# TERRA RIDGE NORTH Grading & Erosion Control Plan El Paso County, Colorado

EL PASO COUNTY PRE-DEVELOPMENT  
 TERRA RIDGE NORTH  
**SITE GRADING & EROSION CONTROL PLAN**

EL PASO COUNTY PRE-DEVELOPMENT
 TERRA RIDGE NORTH
SITE GRADING & EROSION CONTROL PLAN

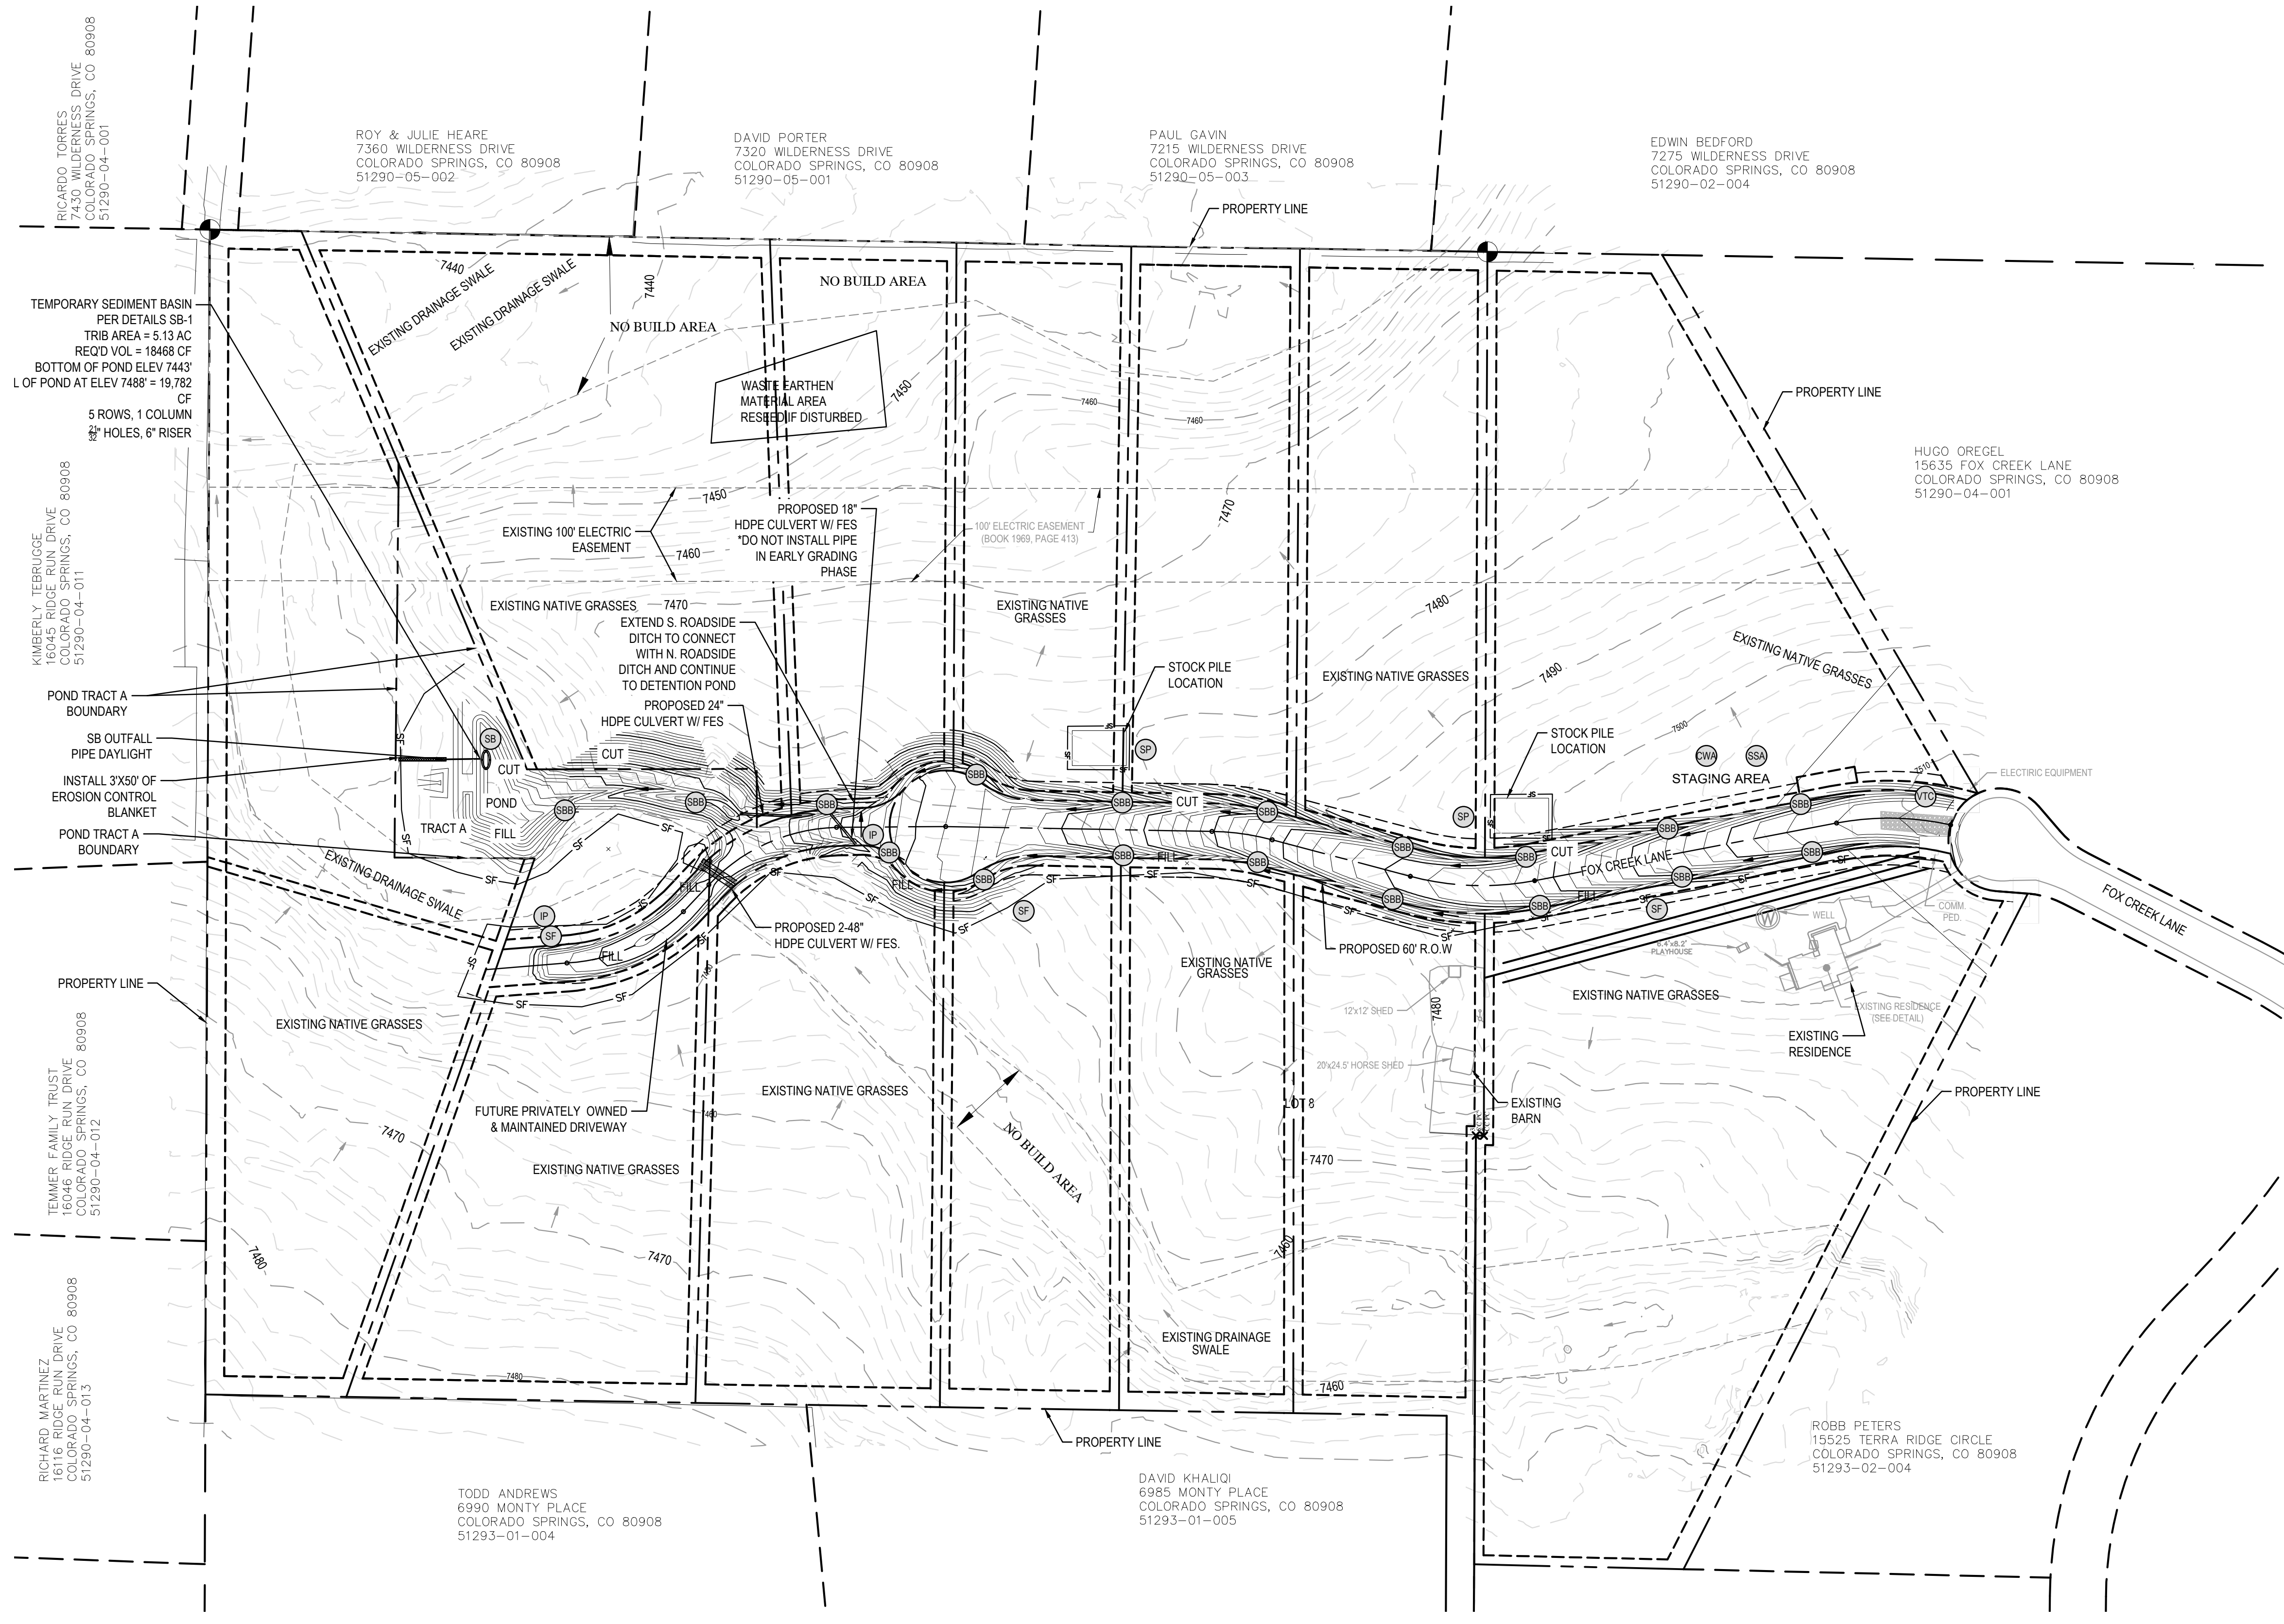
Add a general note: all areas to be vegetated with permanent seeding should also be temporary stabilized via track rolling or some other means.

Unresolved Review 1 comment: show location of seeding and mulching on plans and add to Legend.
